Re: Paradise RV Park
Volcano Rd NW- UPC 101106424915240520
Request for Certificate of Occupancy
Transportation Development Final Inspection
Plan Approval Date 10-21-22 (K08D003)
Certification dated 12-28-23

December 29, 2023

Re: Paradise RV Park
Volcano Rd NW- UPC 101106424915240520
Request for Certificate of Occupancy- 30 Day Temp
Transportation Development Final Inspection
Plan Approval Date 10-21-22 (K08D003)
Certification dated 12-28-23

SITE DEVELOPMENT PLAN FOR BUILDING PERMIT
SCALE: 1"=50'-0"

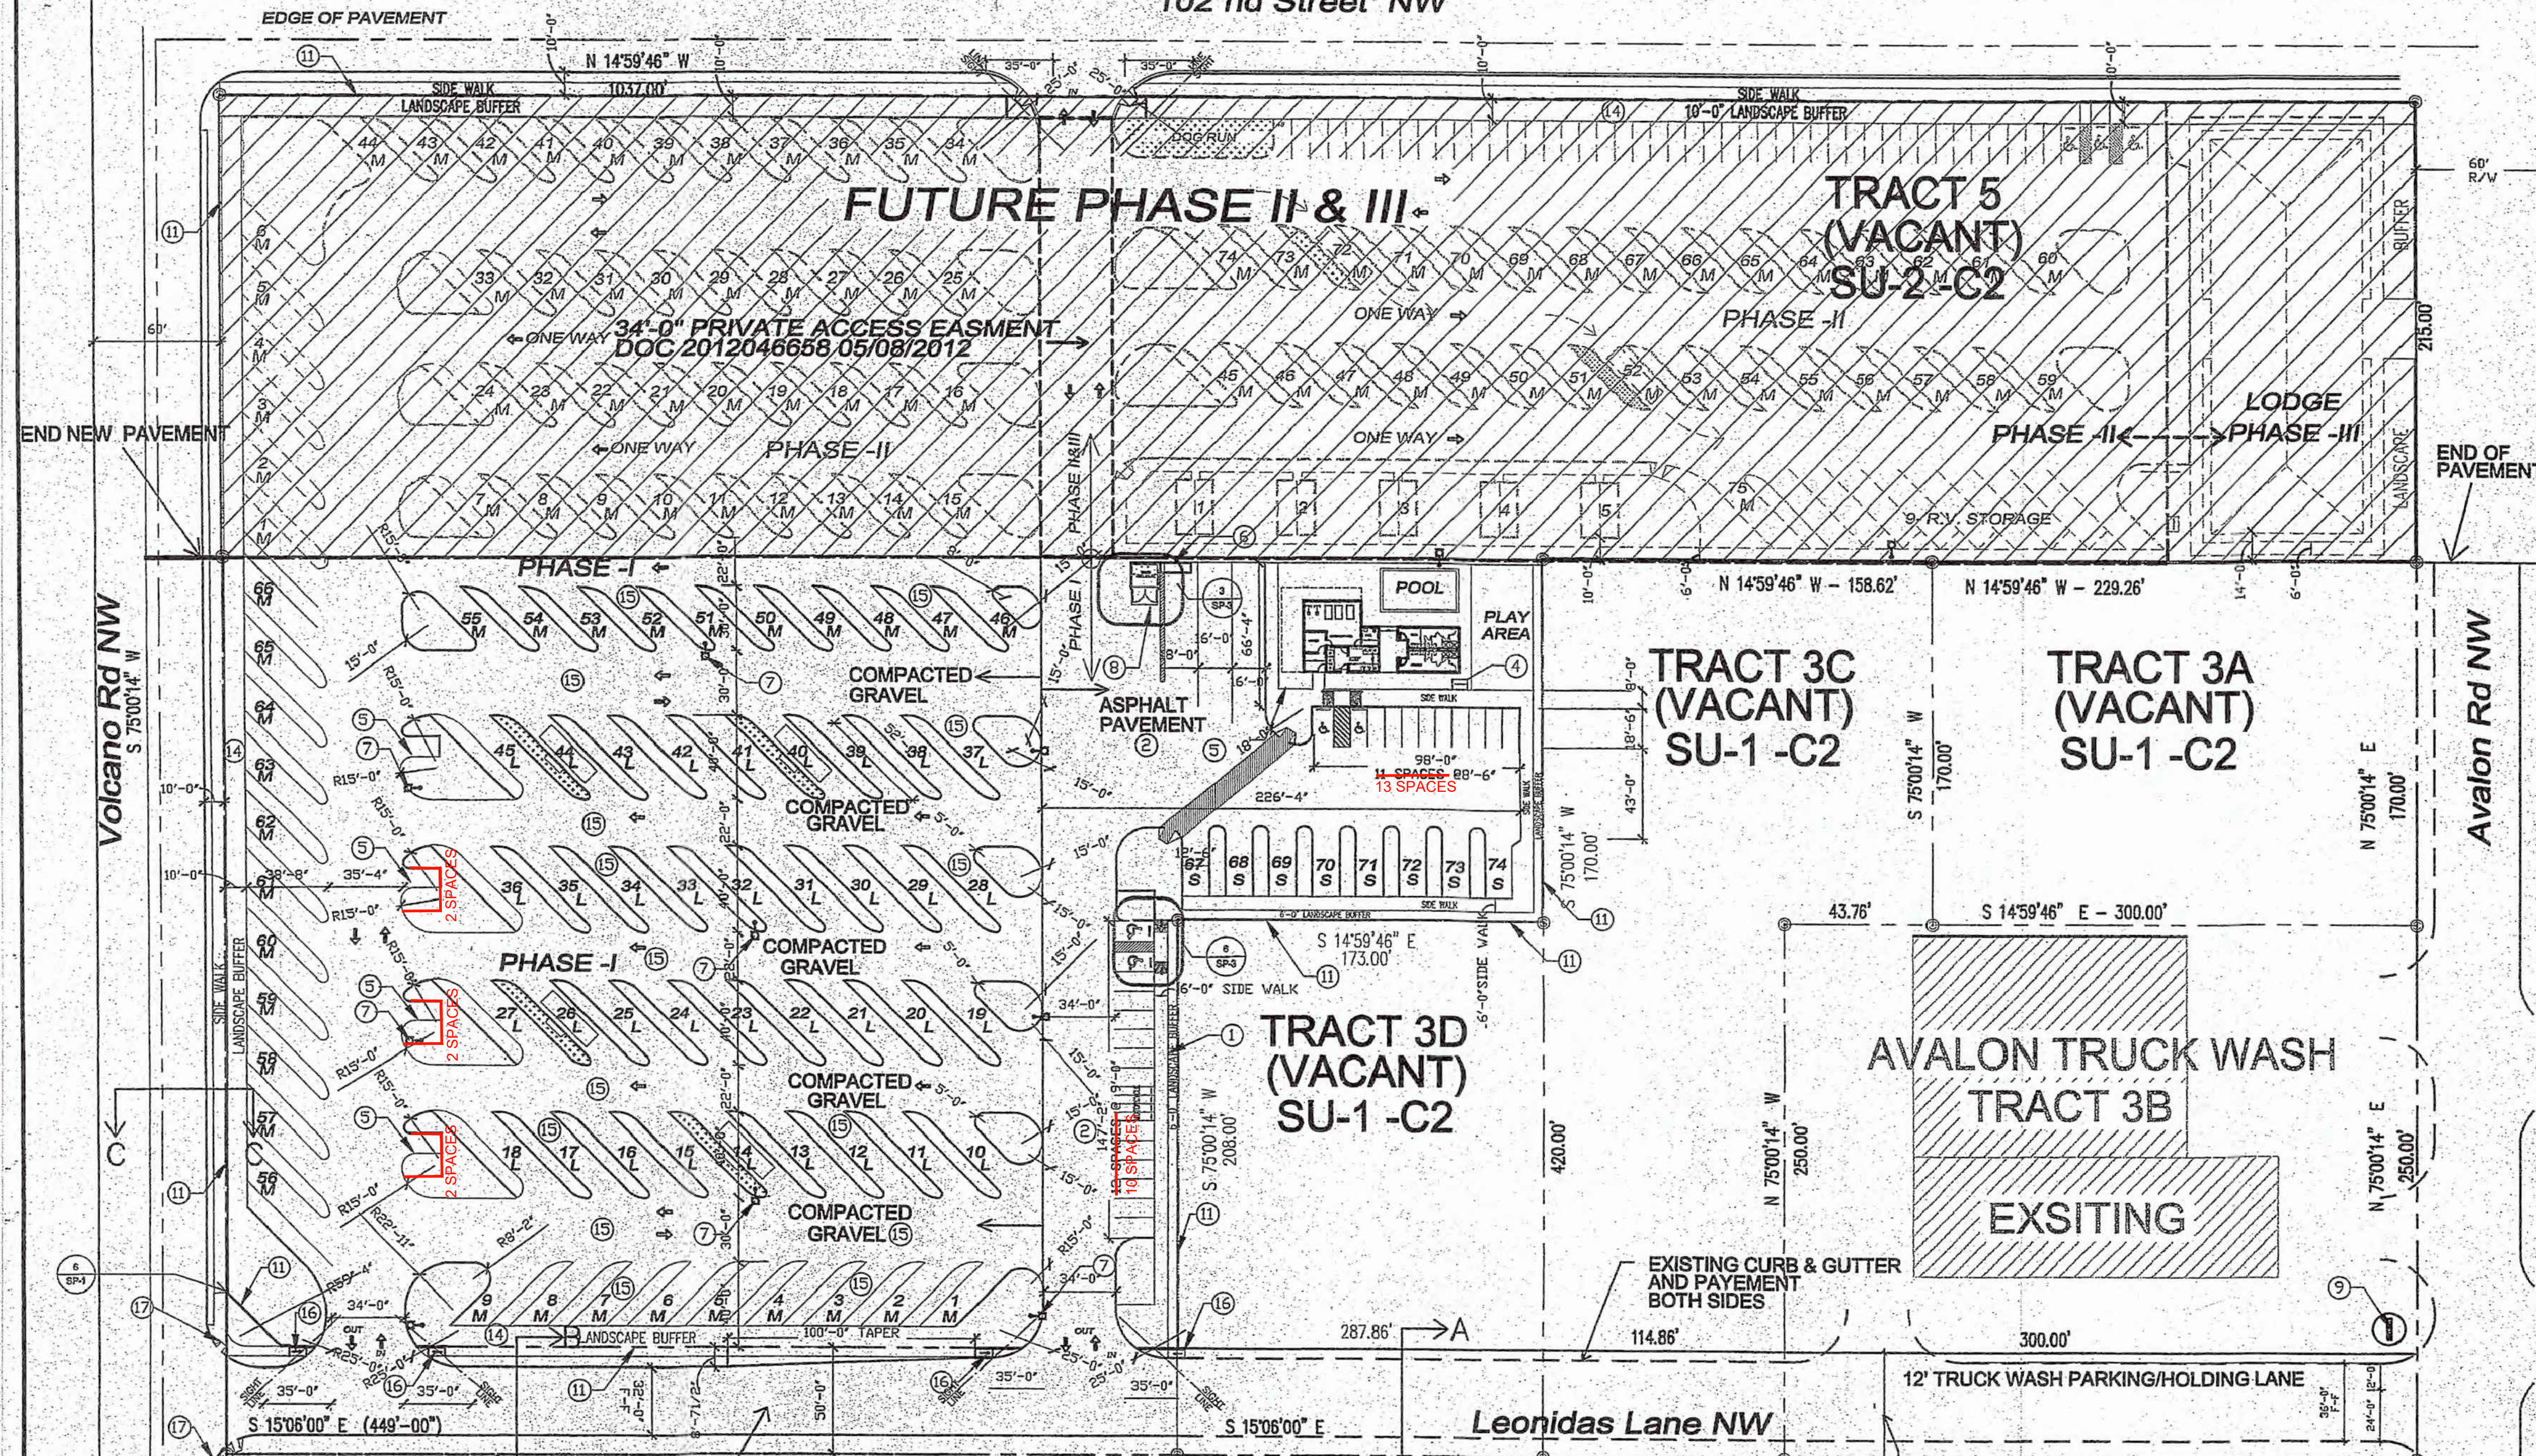
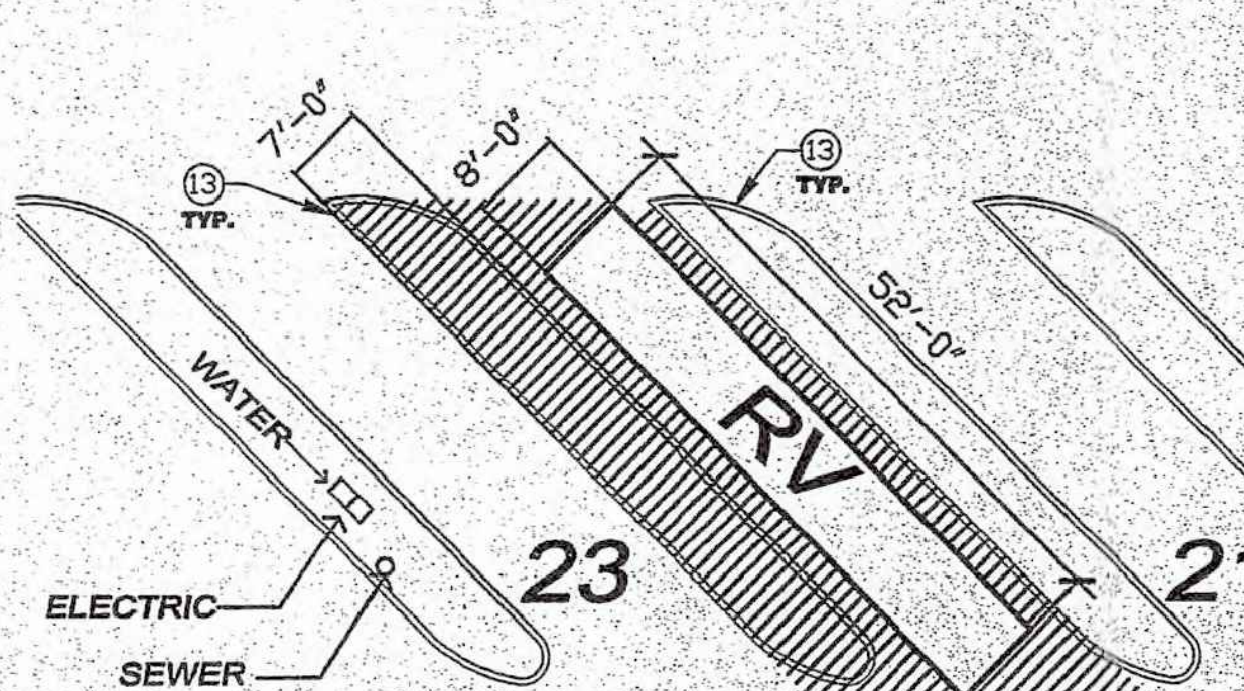
1. Replace the Accessible parking signs with signs that include the language: "VIOLATORS ARE SUBJECT TO A FINE AND/OR TOWING".
2. Add the pavement marking "NO PARKING" at the rear of the accessible Aisle.
3. Have a sign for each motorcycle parking space.
4. Two of the ramps were not flush with the adjoining parking surface.
5. The ramp west of the accessible parking and at the corner (in area of 6/SP-3 Detail on Sheet SP-1 and discussed on-site) had a slope of approximately 12.5%, whereas, the max allowable slope is 8.3%. Replace the ramp with a ramp with an acceptable slope.
